**RE: RESPONSE TO INFORMATION REQUEST FOR THE MAXWELL PROJECT (SSD-9526)**

I refer to the Muswellbrook Shire Council's (MSC's) review of the Submissions Report for the Maxwell Project (SSD 9526) provided to the Department of Planning, Industry and Environment (dated 6 January 2020).

RESPONSE TO MUSWELLBROOK SHIRE COUNCIL  
INFORMATION REQUESTS

Figure 9.1 - Existing and proposed surface water monitoring locations

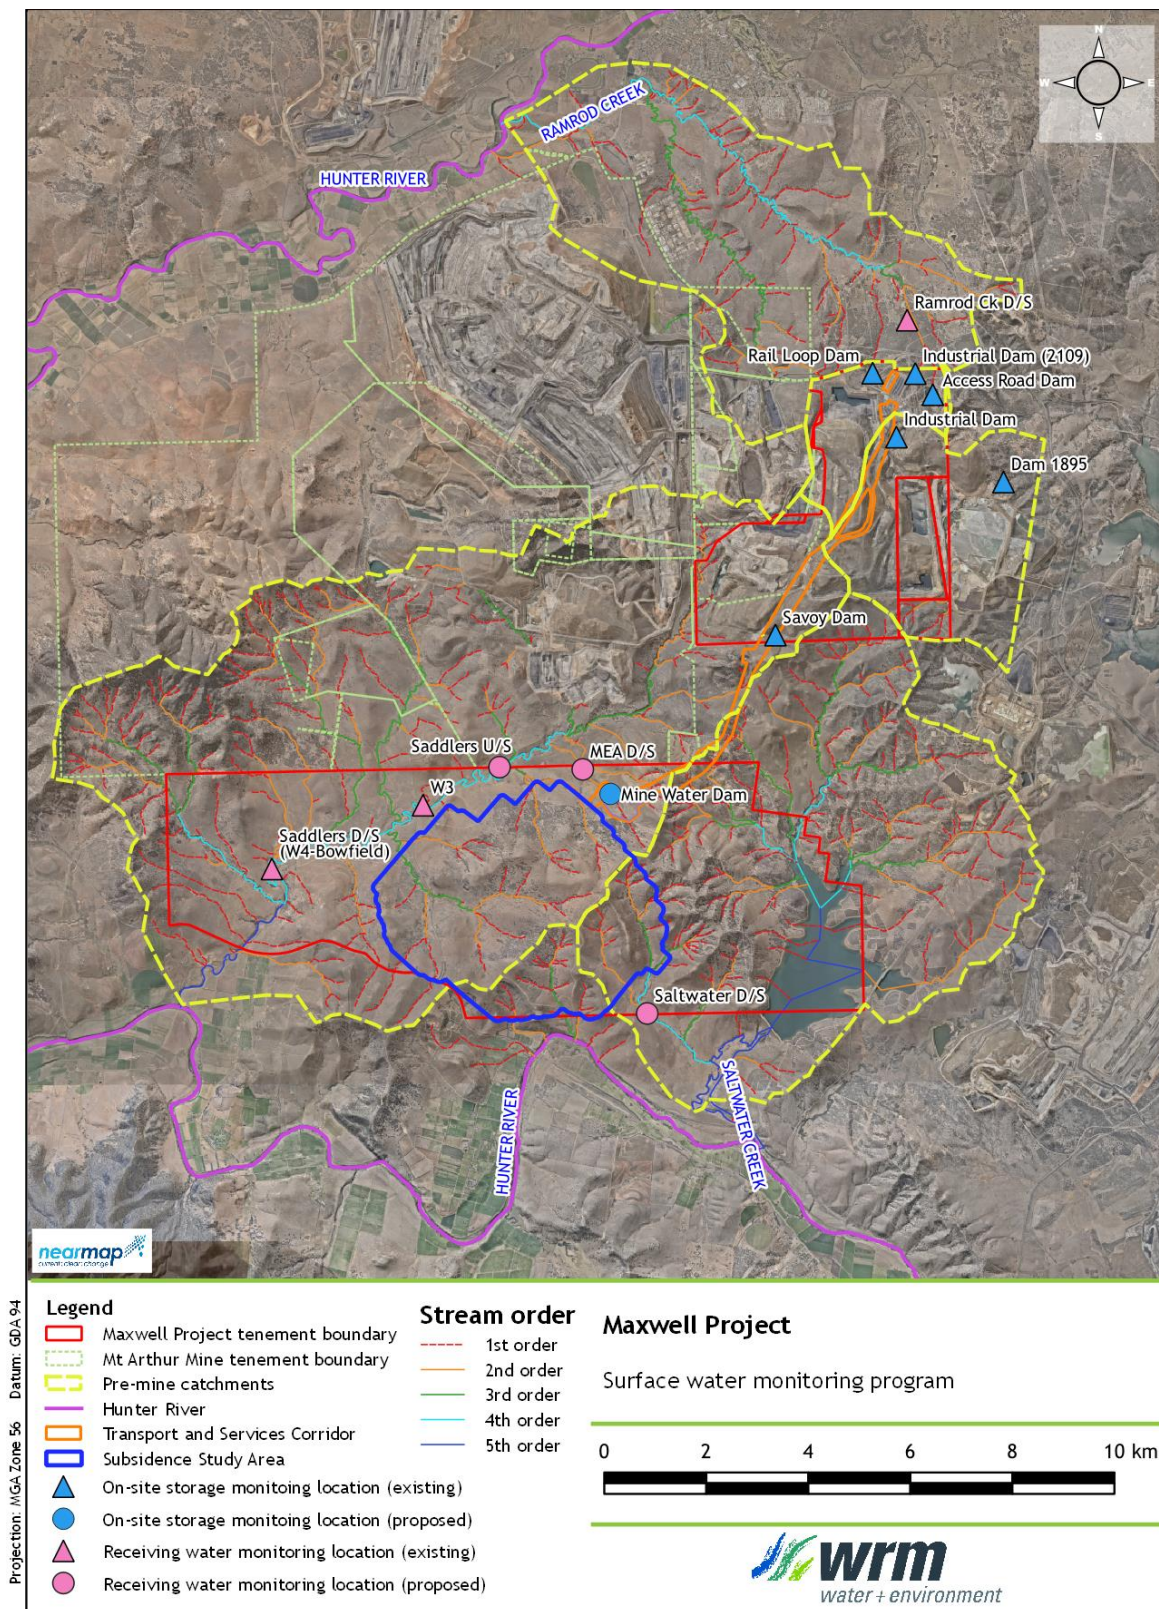
ID	Consolidated Summary of Issue	Response
9	<p>9.0 Council requests that additional receiving water monitoring points be included, in addition to those nominated in Figure 9.1 of the Surface Water Assessment. Council suggests that at the very least a monitoring point be established between W4-Bowfield and W3 that will sample water coming off the majority of the subsidence area before it enters Saddlers Creek. There is also merit in establishing a monitoring point that will cover the largest subsidence area within the southern catchment that drains directly to the Hunter River (as detailed on Figure 9.1 of the Surface Water Assessment), and a monitoring point that would monitor for potential impacts from the Transport and Services Corridor on Plashett Reservoir.</p> <p>...</p> <p>Noted. Appropriate conditions of approval required to ensure this occurs.</p>	<p>MSC has reviewed the Submissions Report and has not requested any additional information from Malabar regarding this issue.</p>
